DEPARTMENT OF PARKS AND COMMUNITY SERVICES

October 8, 2024

Subject: Jimmy Camp Creek Drainage Basin Study, 2nd Submittal - Administrative Comments (MP-23-002)

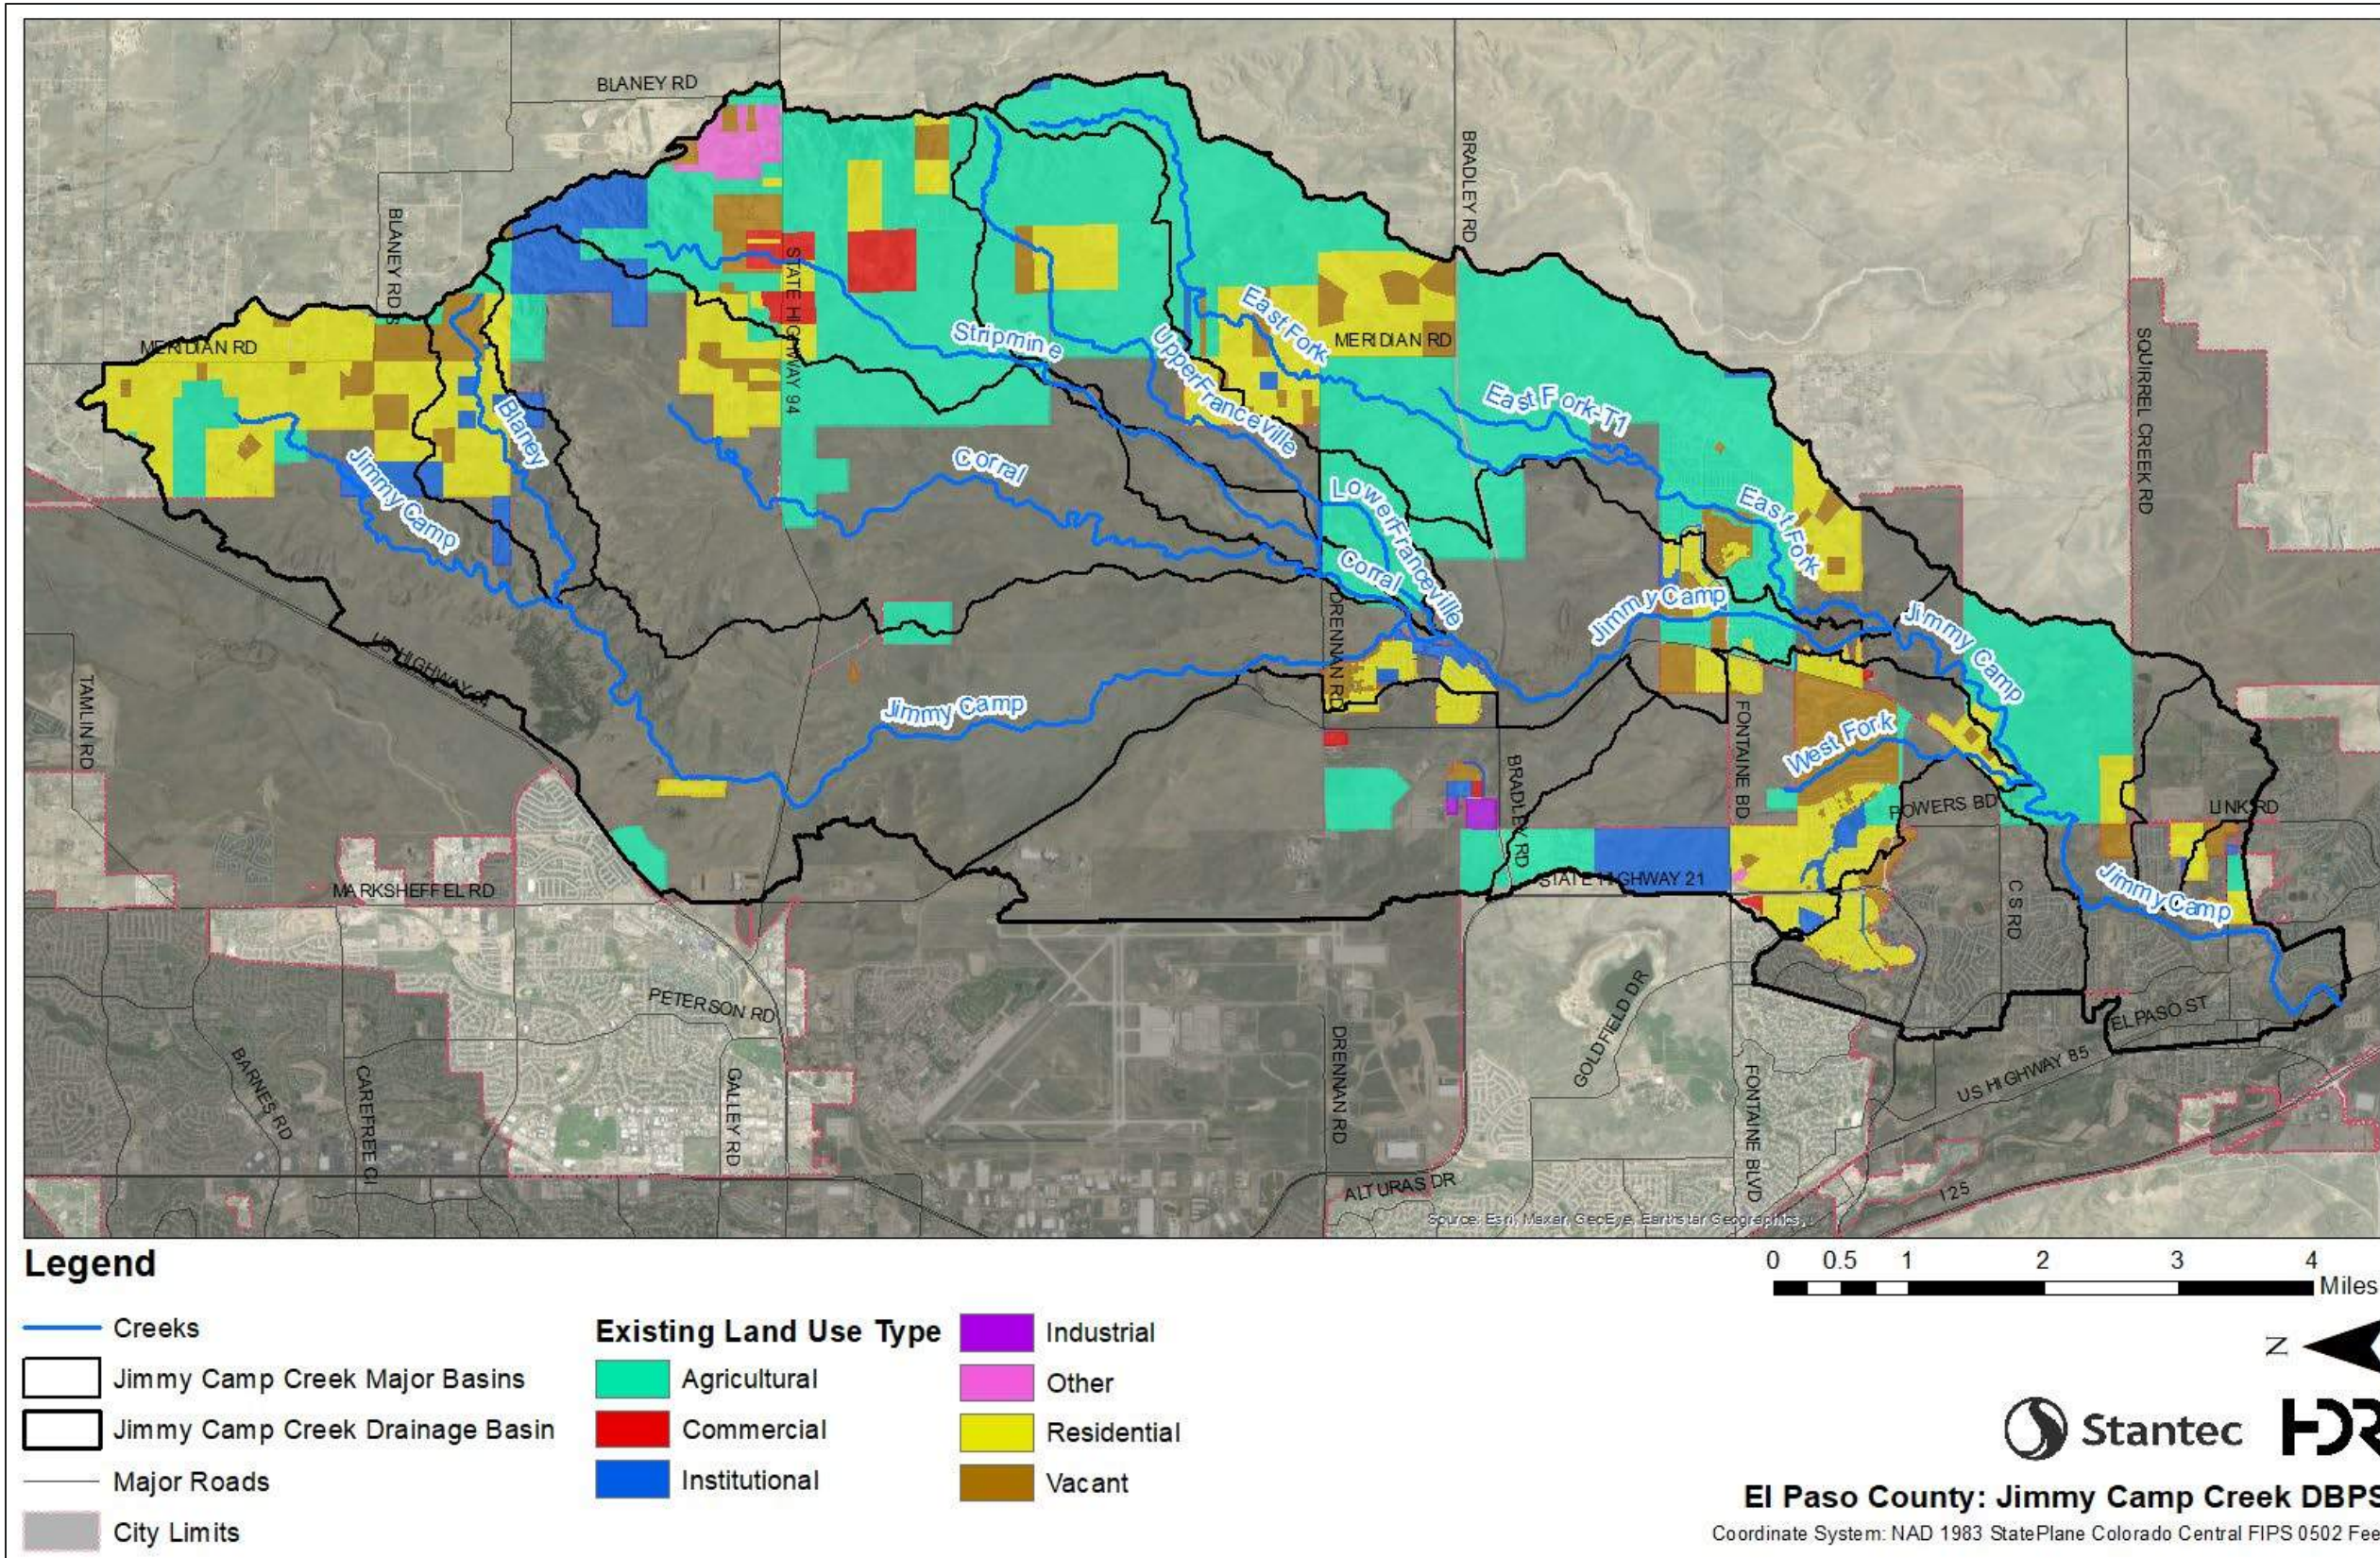
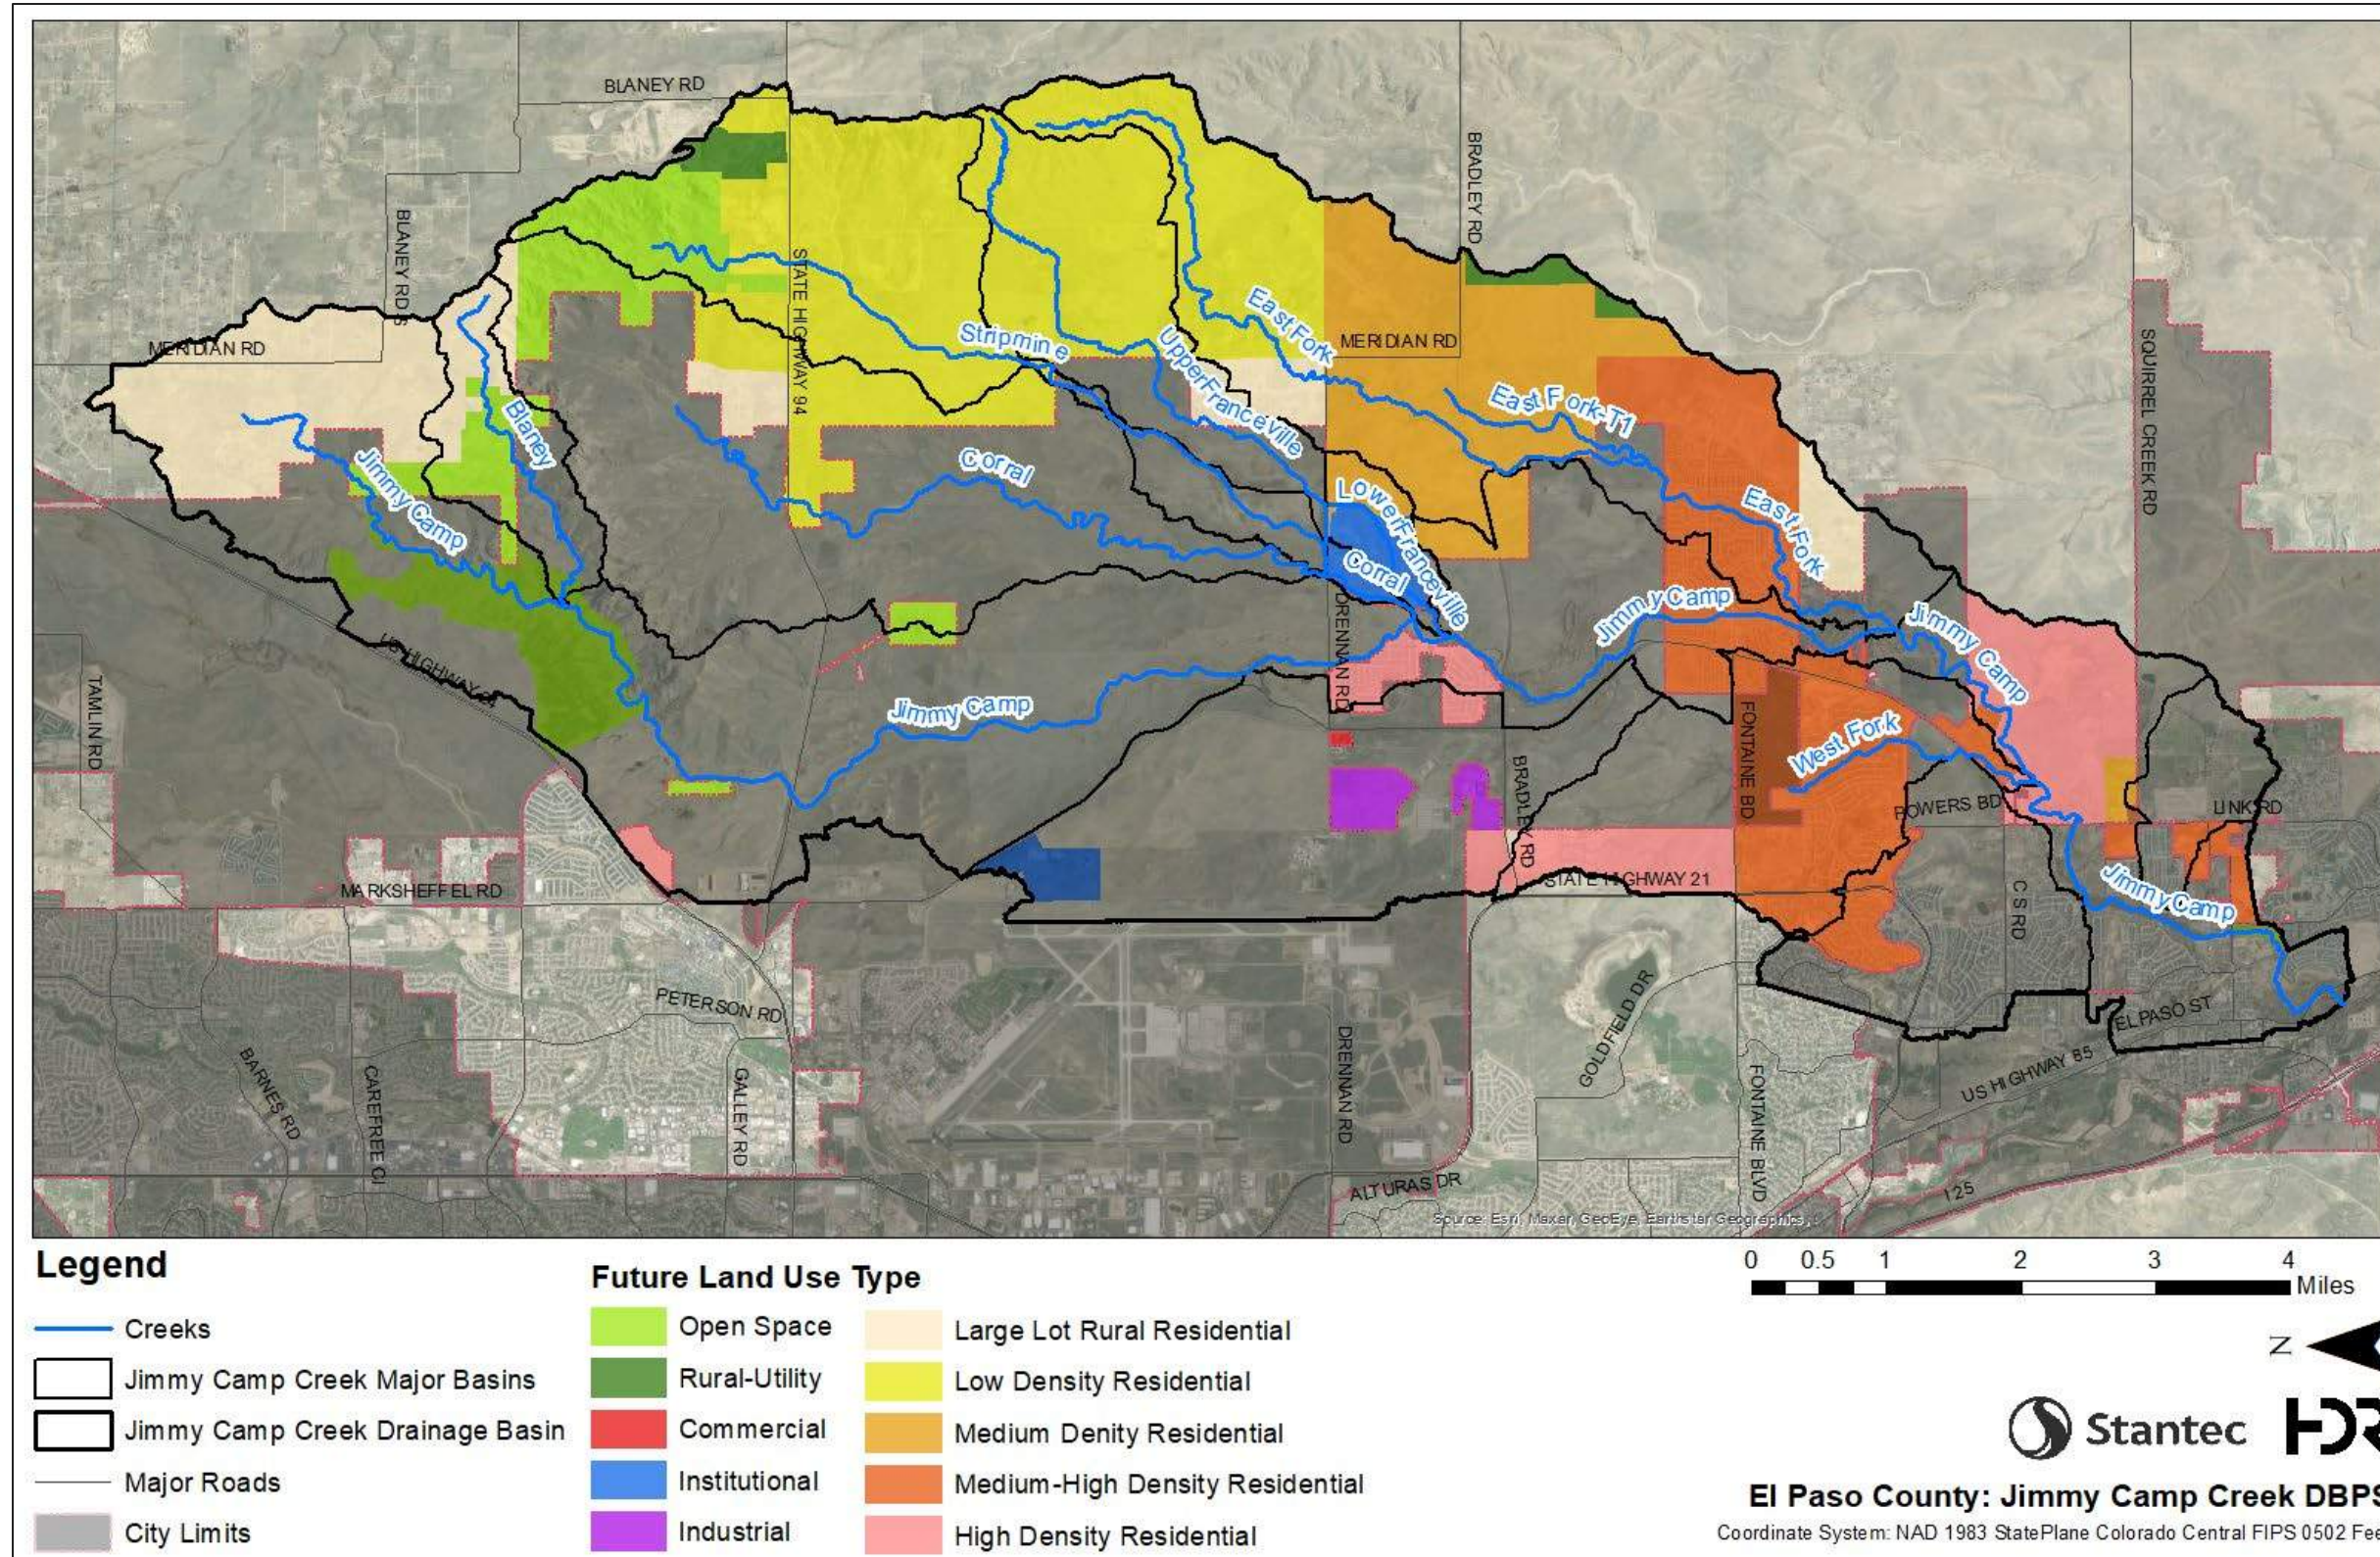
- *Additionally, the City of Colorado Springs is planning, as of the date of this report, on annexing and rezoning two properties in the Jimmy Camp Creek basin to parkland. The first property (Jimmy Camp Creek Annexation Filing No.1) consists of 410.3 acres located between the Blaney Rd S. and Meridian Rd. intersection and Jimmy Camp Creek in the upper watershed. The second property (Corral Bluffs Annexation Filing No. 1) consists of 920.4 acres located north of the Aztec Family Raceway in the northeast corner of the basin. These locations are shown as Open Space in the Future Land Use Map discussed below.*

- There are multiple proposed **[Candidate]** Open Spaces **[Areas]** that would be located fully or partially in the Jimmy Camp Creek Drainage Basin. Falcon Garrett Roads Open Space would occupy the broad northeast trending ridge that separates upper Jimmy Camp Creek from the East Fork Sand Creek in the northeast headwaters of the Drainage Basin. Corral Bluffs open space would be connected to the southeast of Falcon Garrett Road and would provide an opportunity for a regional trail alignment linking Fountain Creek with Colorado Spring’s proposed Jimmy Camp Creek Park. The proposed Fountain and Jimmy Camp Creek Open Space would protect the floodplains of both creeks and the globally-vulnerable Arkansas darters that live in the spring-fed marshes adjacent to the main creek channels (EPC, 2013) **[2022]**.
